Sizewell C (SZC)

Written Summary of Oral Case

Issue Specific Hearing 13 Landscape, Visual Impact, Design and Terrestrial Heritage

**DRAWING TITLE:**  
 SOUTHERN PARK AND RIDE  
 PROPOSED LIGHTING AND CCTV PLAN  
 KEY PLAN

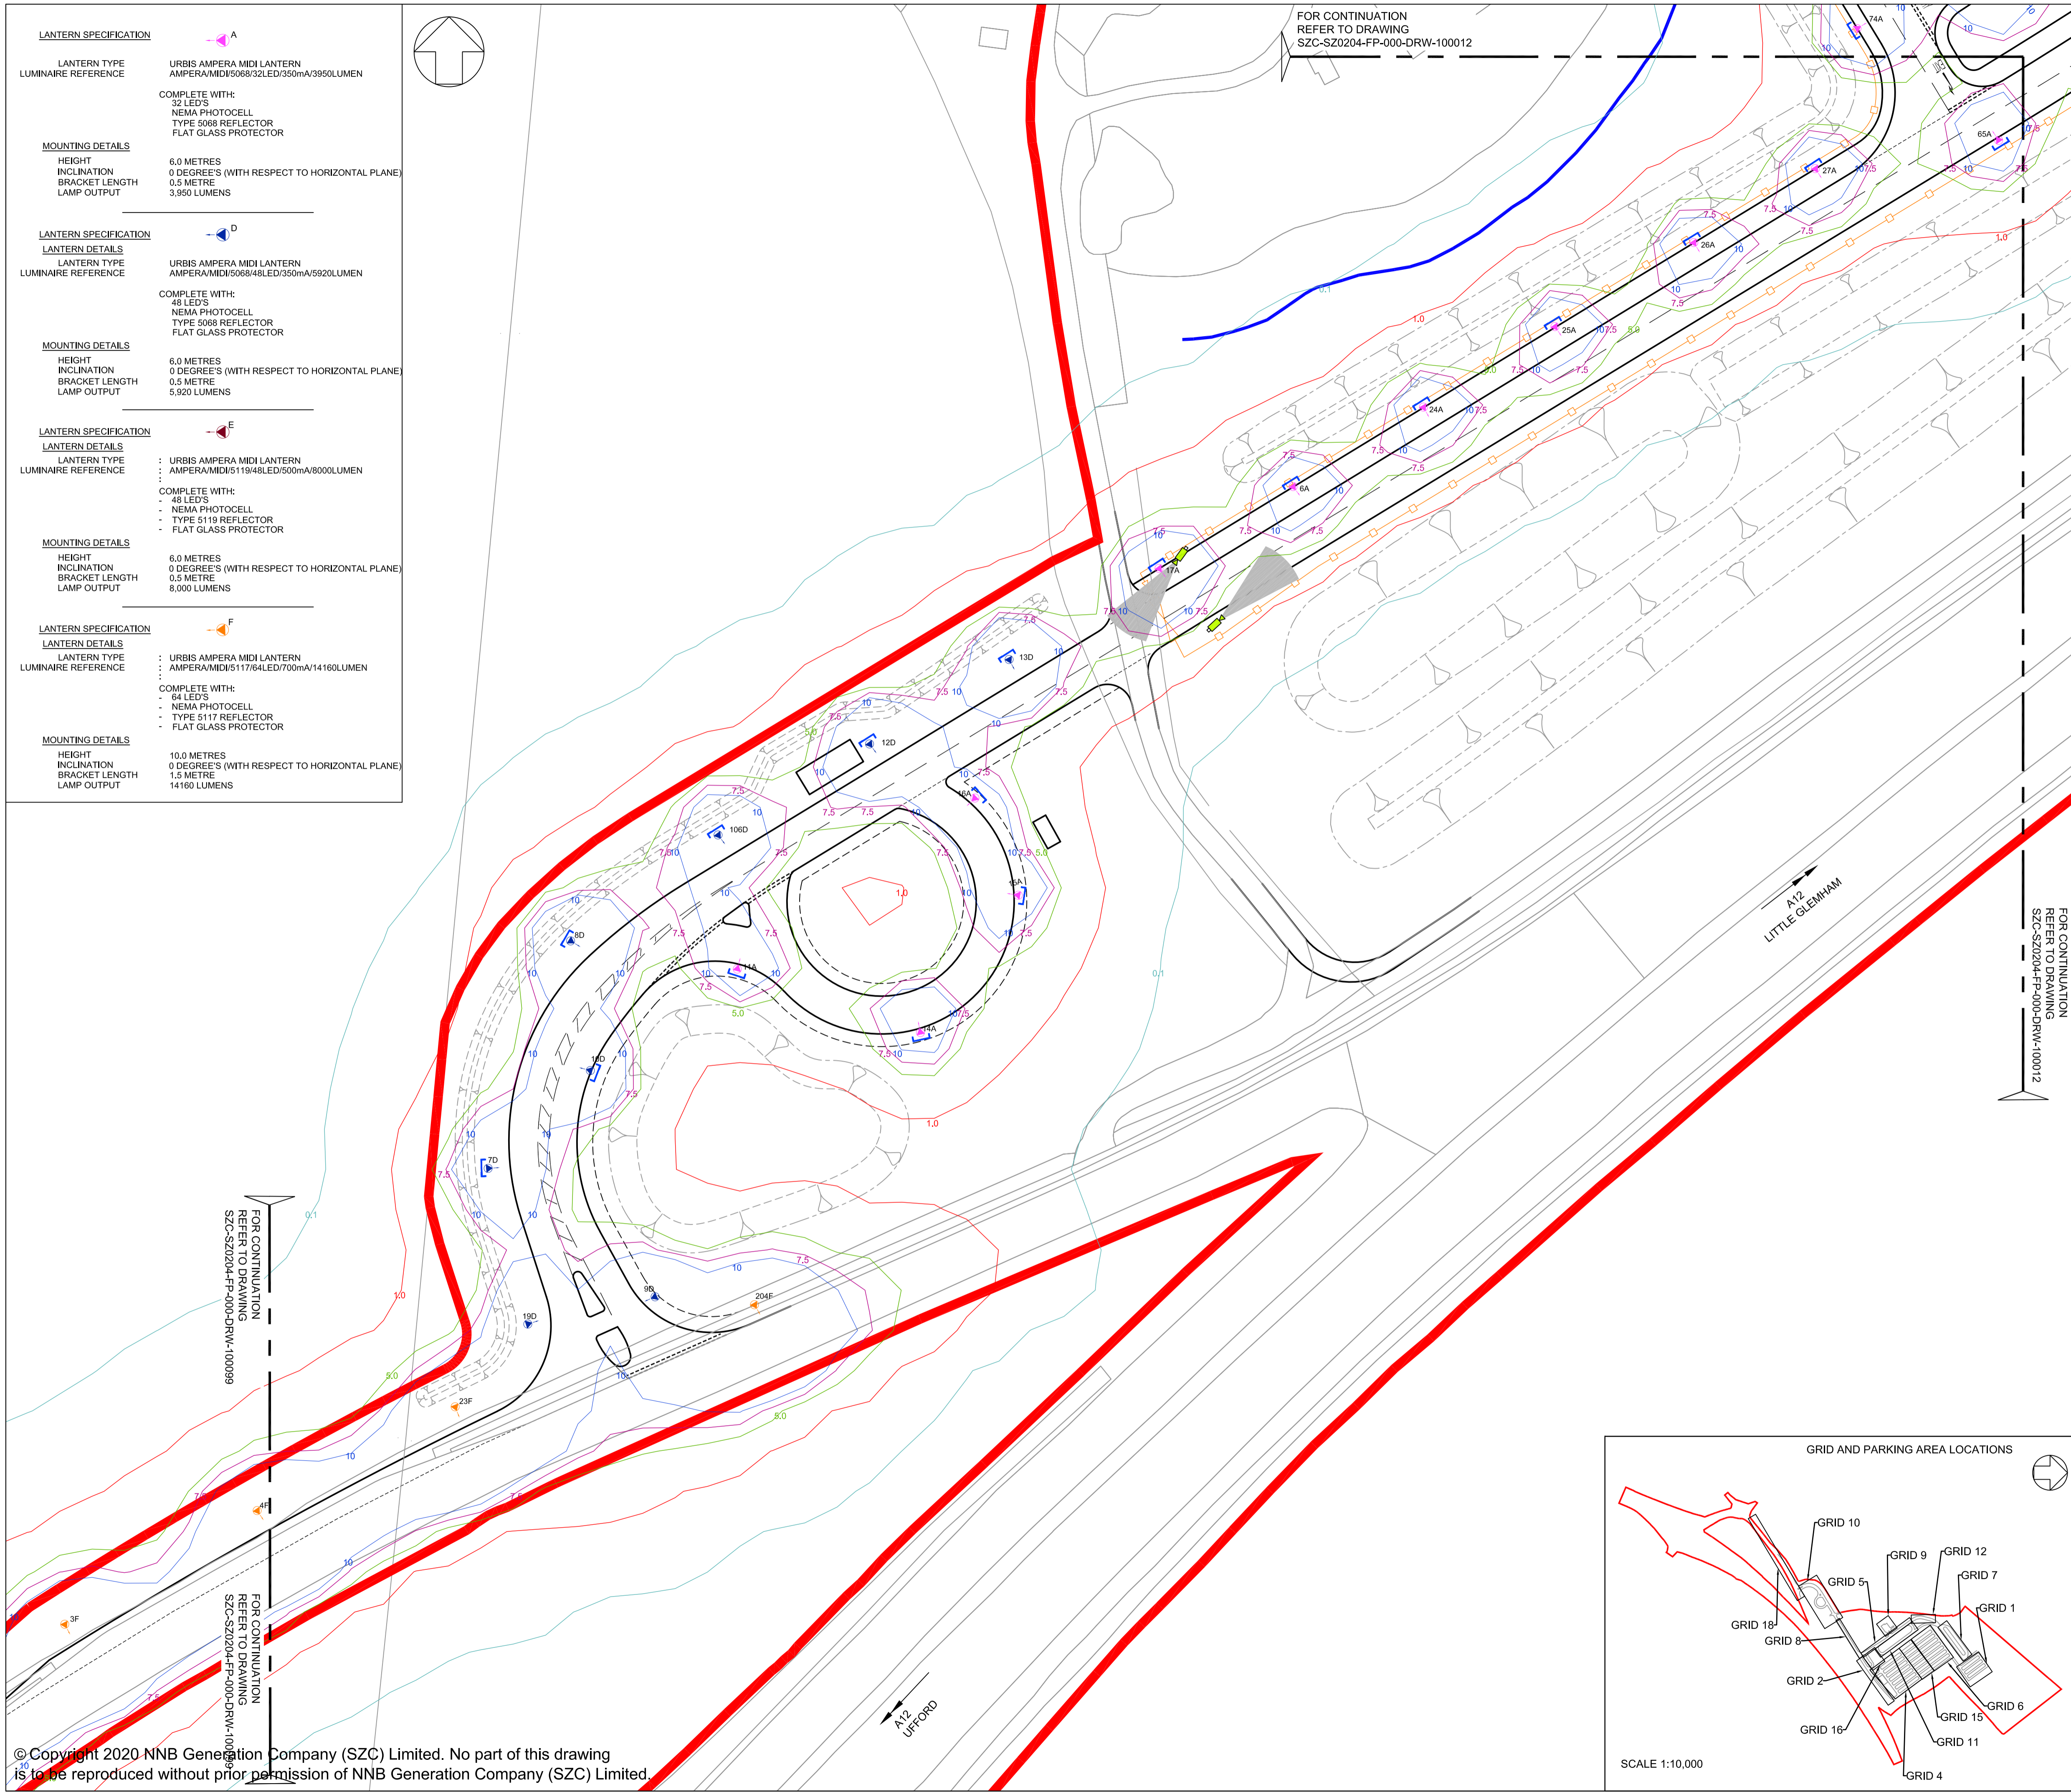
<p>and landscaping provision ▪ cumulative effects</p> <ul style="list-style-type: none"> • Additional monitoring and mitigation suggestions 	<p>ESC expects that the detailed designs in general accordance with the Design Principles will ensure that legacy planting benefits are delivered and that light spill is minimised. The principles need to be amended to ensure that they can achieve that.</p> <hr/> <p>Additional monitoring and mitigation suggestions</p> <p>ESC expects that at discharge of requirements stage, lighting options that ensure the least amount of upward and lateral light spill are proposed and agreed. Planting options to address lateral light spill should also be considered (LI.1.83 [REP2-176]). The Design Principles should be amended to ensure this.</p> <p>ESC accepts that the described tree and hedge planting would generally be successful in minimising the visual impact of the Southern Park and Ride in views from the surrounding landscape and would integrate with the surrounding landscape (LI.1.120 [REP2-176]).</p> <p>Screening mounds and new planting have been described in the ES and full details can be agreed at discharge of requirements stage, as necessary, along with lighting strategies. It is anticipated that as much new planting as possible can be left as legacy planting after completion and therefore its nature and location will need to be suited to the prevailing local landscape character.</p>
